DECISION DELEGATED TO HEAD OF PLANNING
DECISION DELEGATED TO HEAD OF PLANNING
DECISION DELEGATED TO HEAD OF PLANNING

Application No:	H16-1080-23	Applicant:	Ringwood & Simpson Ltd
Proposal:	Erection of detached dwelling and garage - approved under H16-0047-23. Modification of Condition 2 to allow amendments to previously approved plans		
Location:	Rear Of 175 Hawthorn Bank Spalding		
Terminal Date:	31st January 2024

Drawing: Tree Protection Plan - Construction (ii)

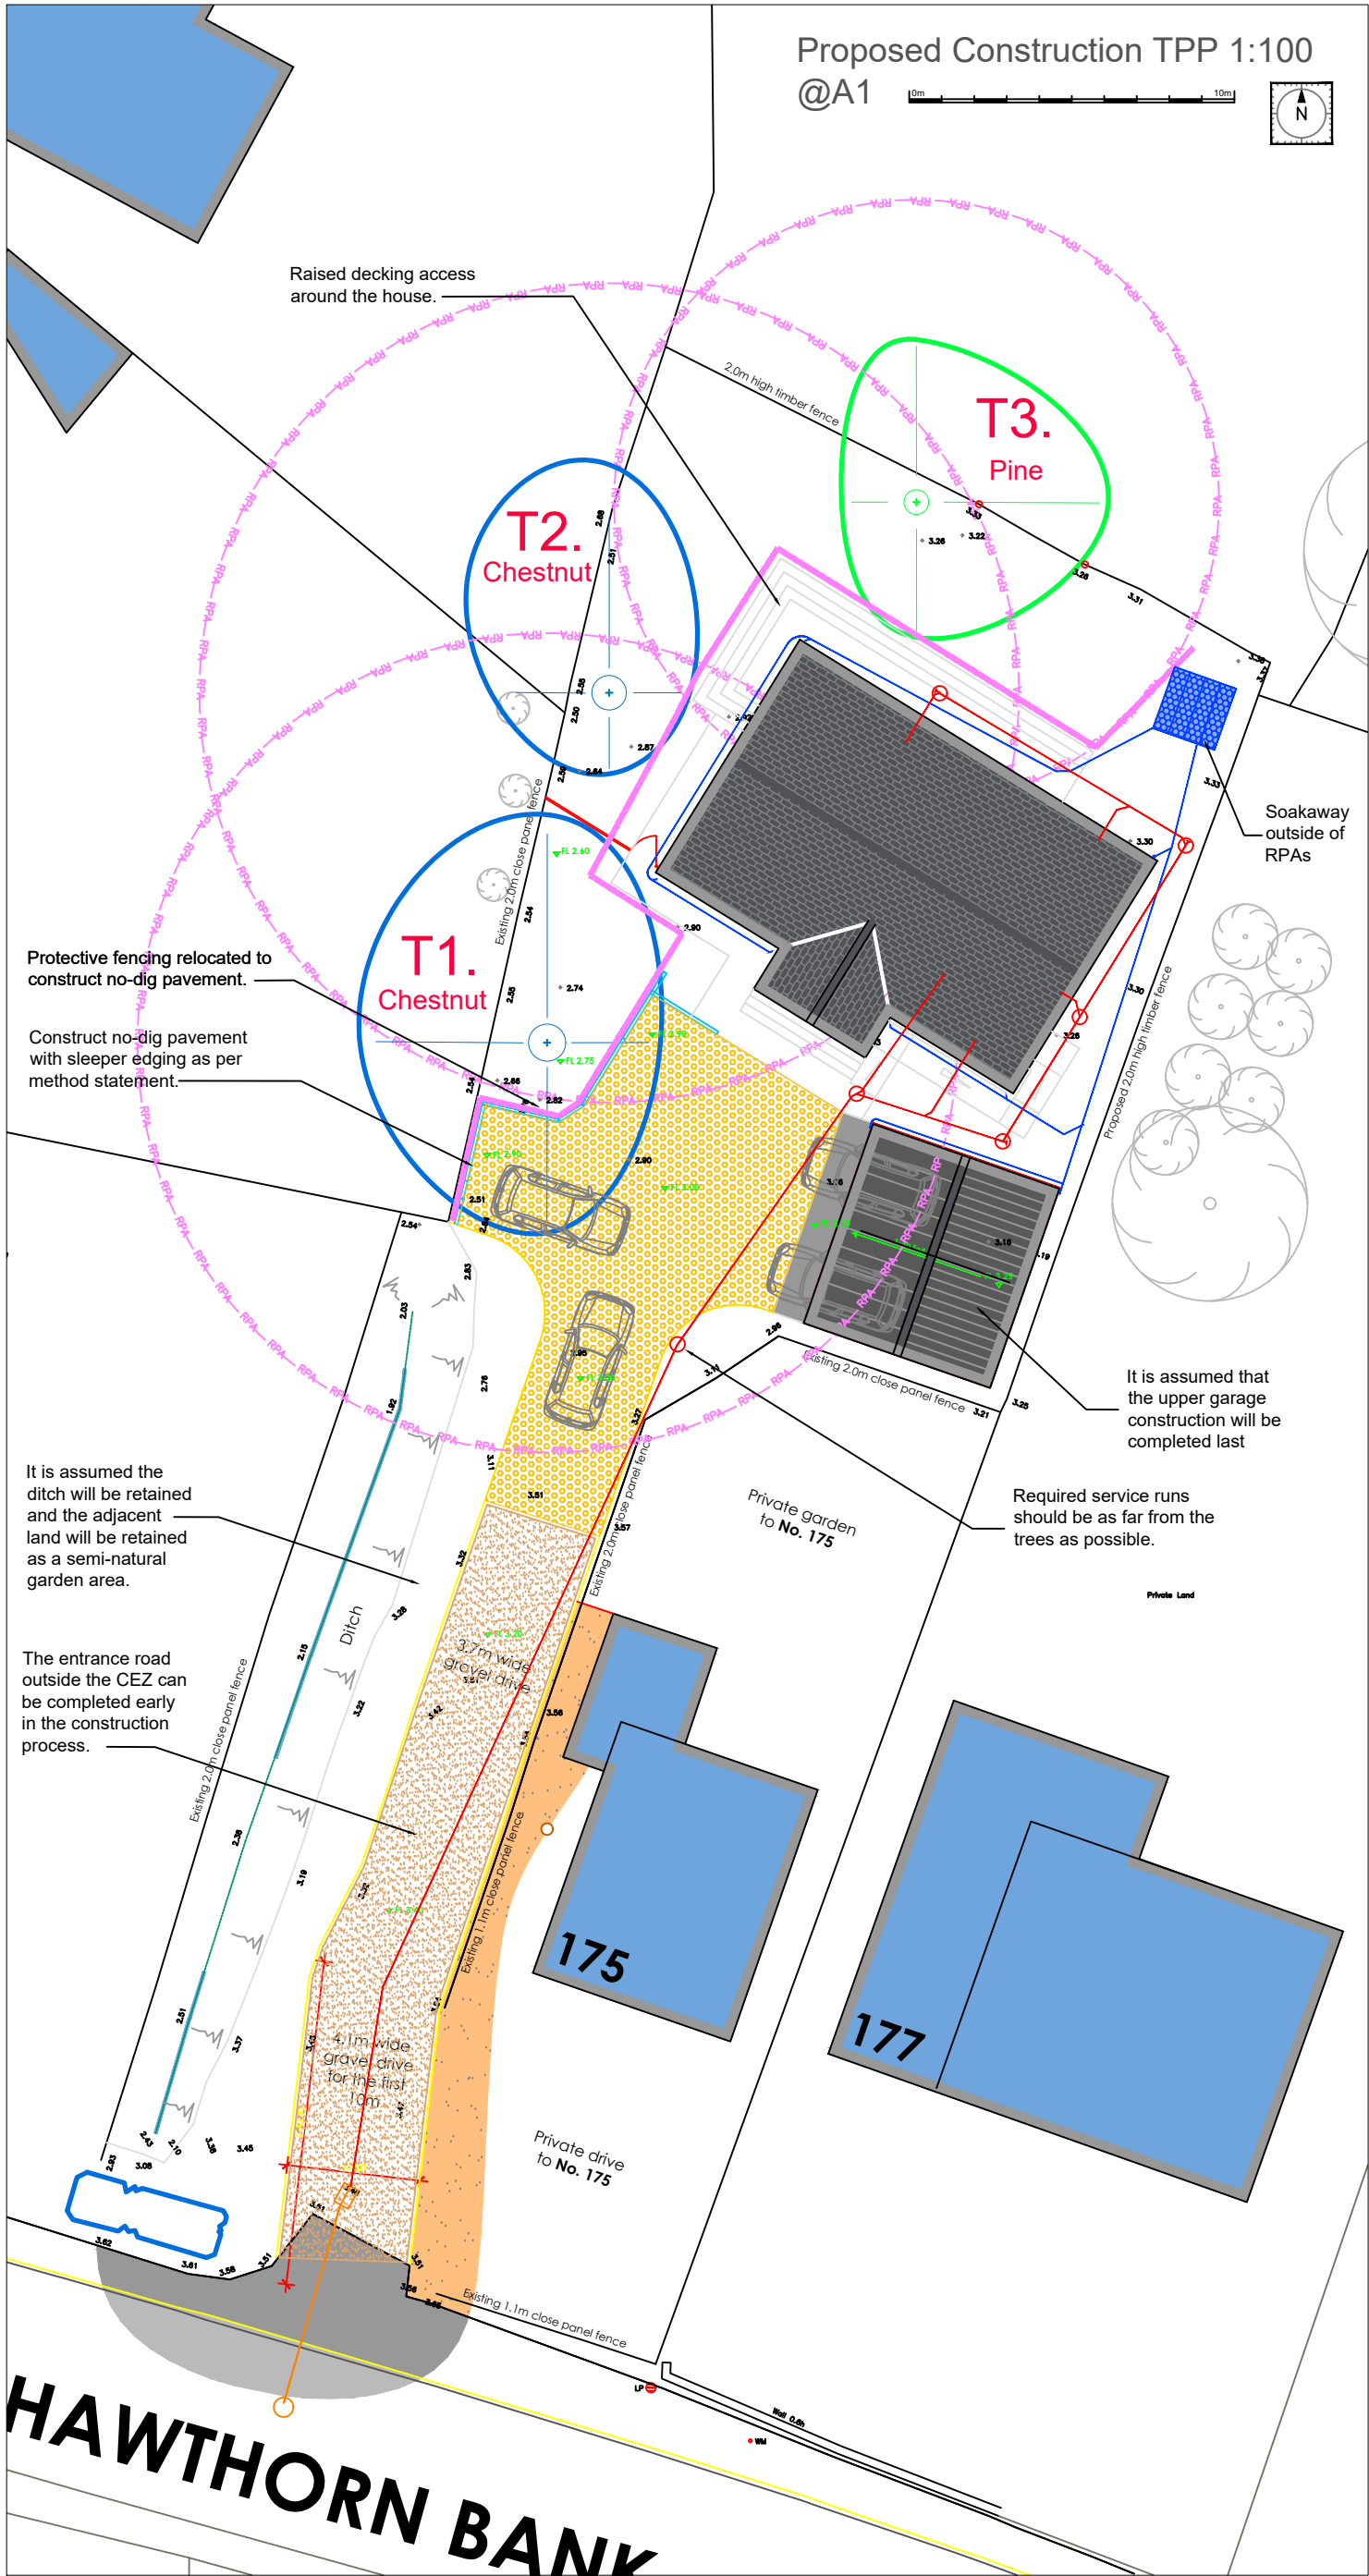
The applicant has provided a tree survey and tree protection plan. Condition 9 of the previously approved planning application required that these trees were protected during construction. The arboriculture supporting information demonstrates how these retain trees will be protected and is considered acceptable. Any permission will therefore approve these documents to ensure that retain trees are protected during construction.
